Comments on the Applicant's Response to Deadline 6 Submissions [part 8 - Residents Businesses] by Wiliam David Moore

00:00 on 25/04/2021 to 00:00 on 26/04/2021

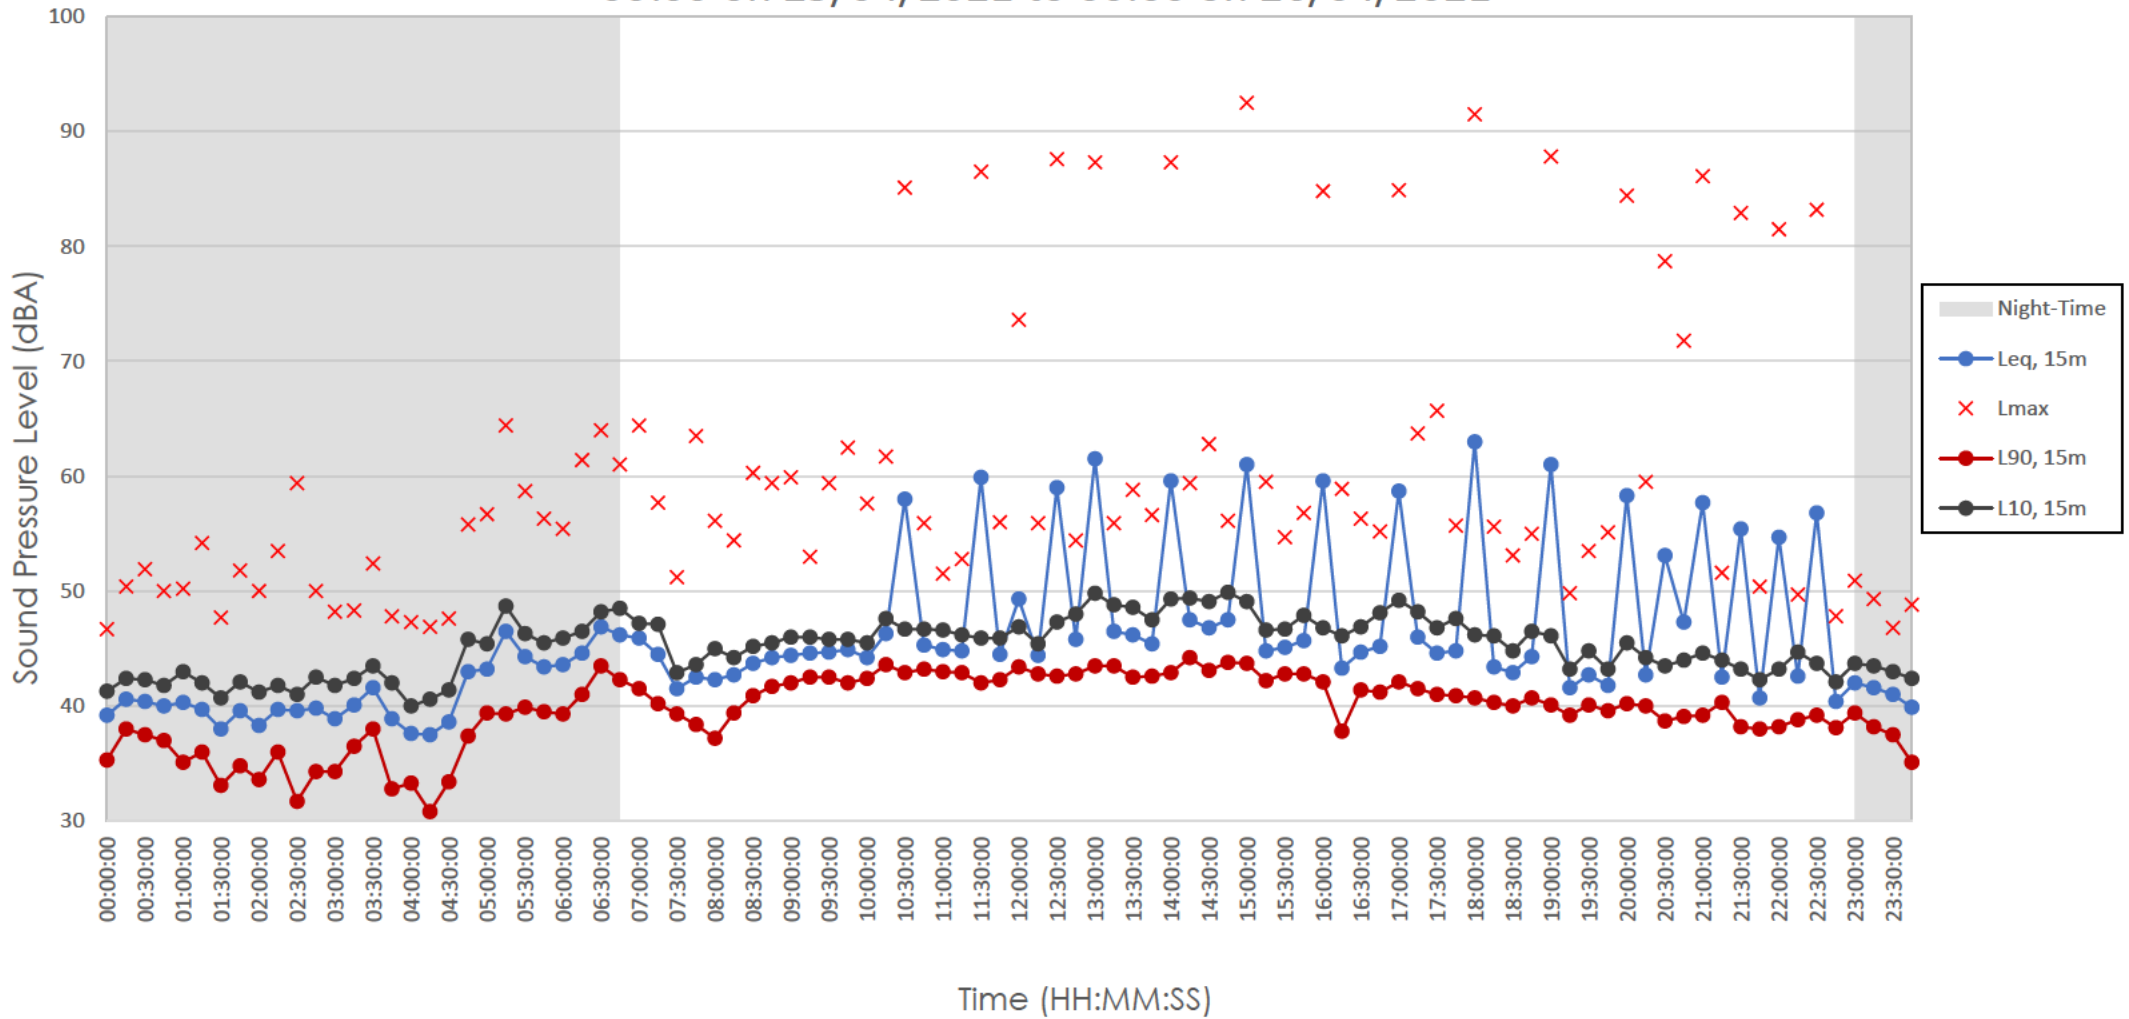
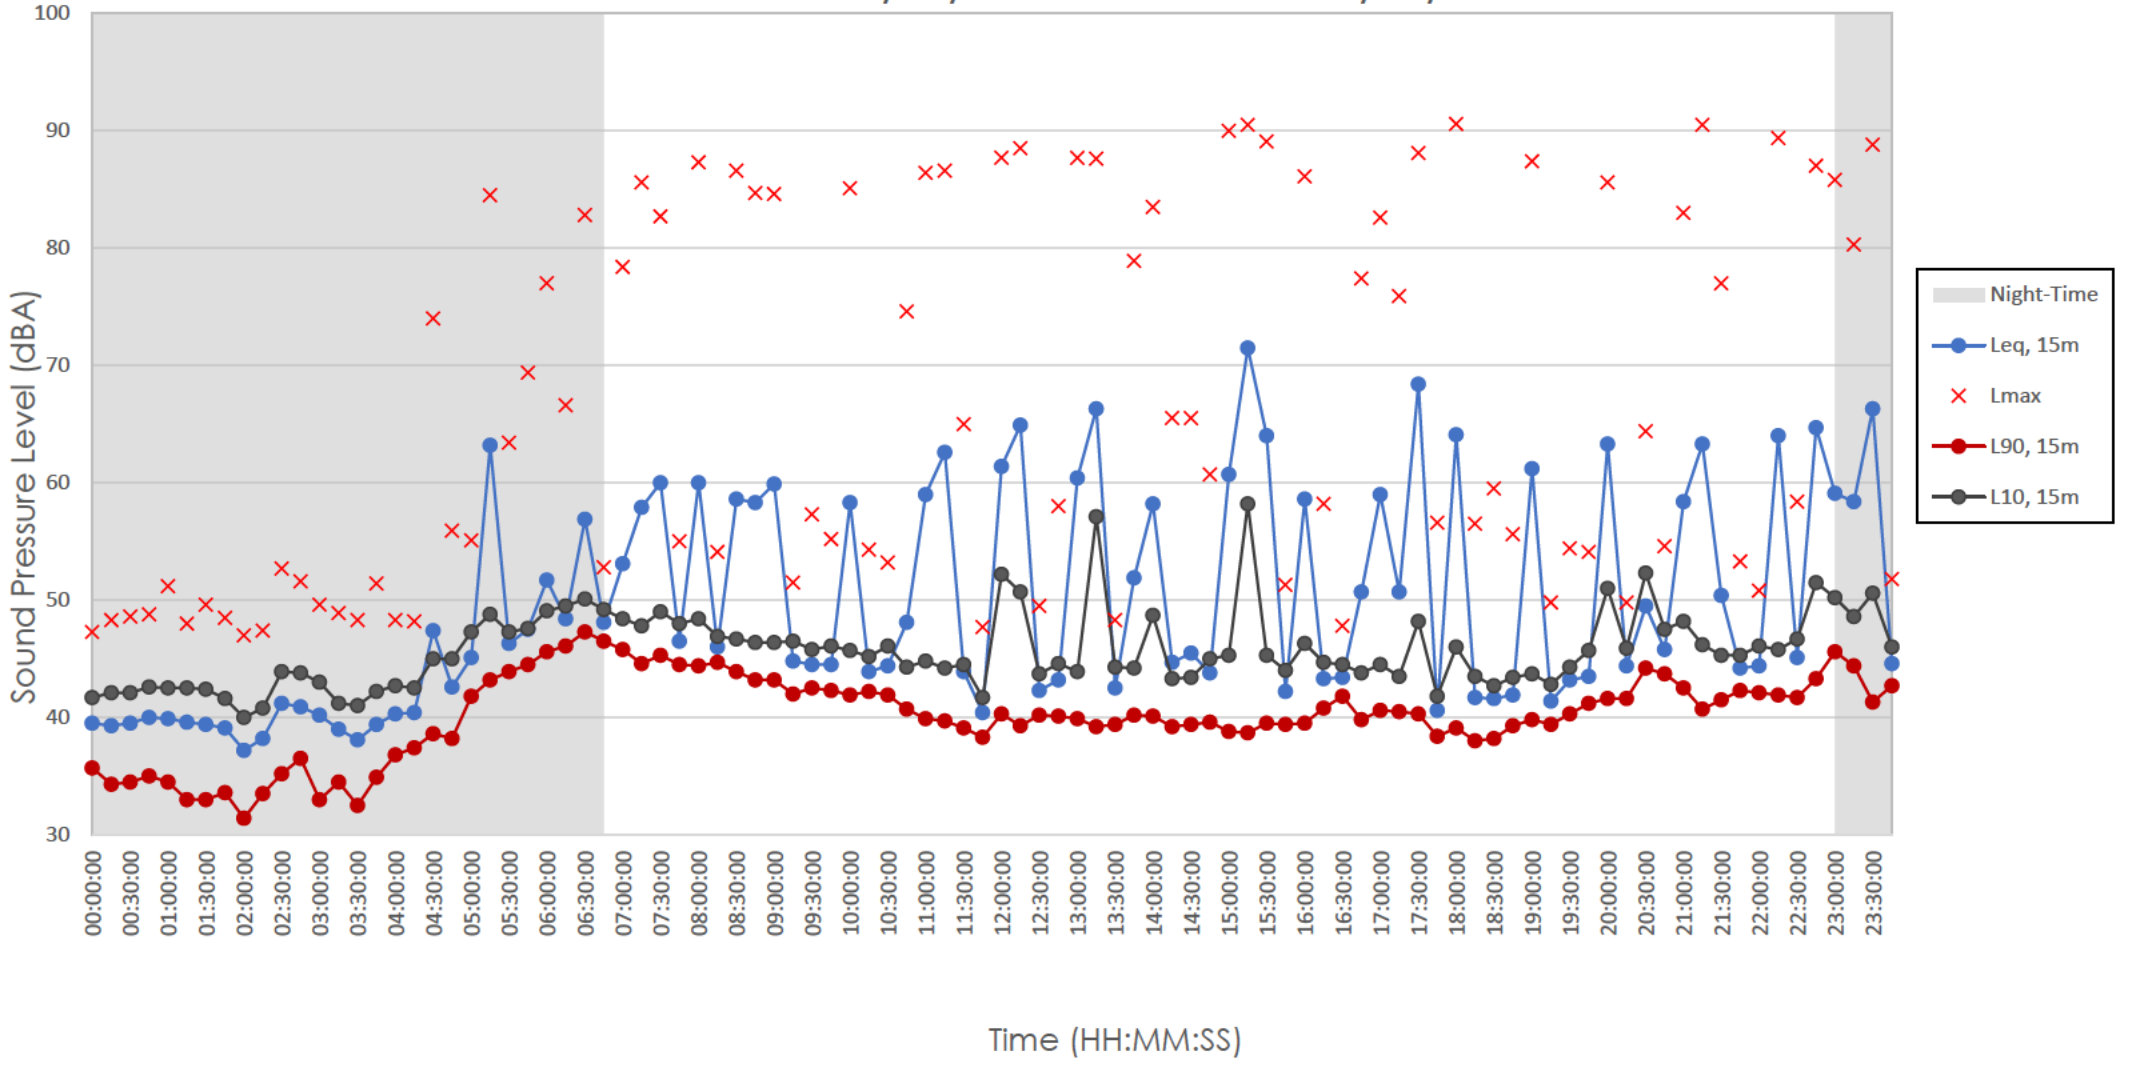
1. The applicant's noise assessment update note doesn't address all the NSRs associated with NMP4.

The applicant has started attributing the same contour claims from Billington Road East to NSR 1.

Look at the location of NSR 1 on [the applicant's road noise contour map](#). It's in the applicant's 45.0-49.9 **LA10 18hr** road noise contour. Yet the applicant is attempting to attribute 55 dB LAeq of daytime road noise to the NSR.

Like all the NSRs in the applicant's Update Note, NSR 1 is outside the applicant's rail noise contours, yet the applicant is still attempting to attribute 50 dB of rail noise to the NSR during all time periods.

The applicant's claim that NSRs experience more ambient road noise than NMP4, and therefore the sound of train pass bys measured by NMP4 during different time periods shouldn't be attenuated, is demonstrably inapplicable to NSR 1. NSR 1 is located in a **lower** road noise contour than NMP4.

It is assumed that this refers to the resultant noise levels at NSRs 1 and 24 which are now shown below

NSR	Daytime (0700-2300)				Night-time (2300-0700)			
	Rating Level	Ambient Level	Rating + Ambient	Increase	Rating Level	Ambient Level	Rating + Ambient	Increase
1	47	56.2	56.7	+0.5	47	54.8	55.5	+0.2
24	50	56.2	57.1	+0.9	47	54.8	55.5	+0.2

The reasoning already provided for the use of ambient noise levels measured at NMP4 is also applicable to NSRs 1 and 24
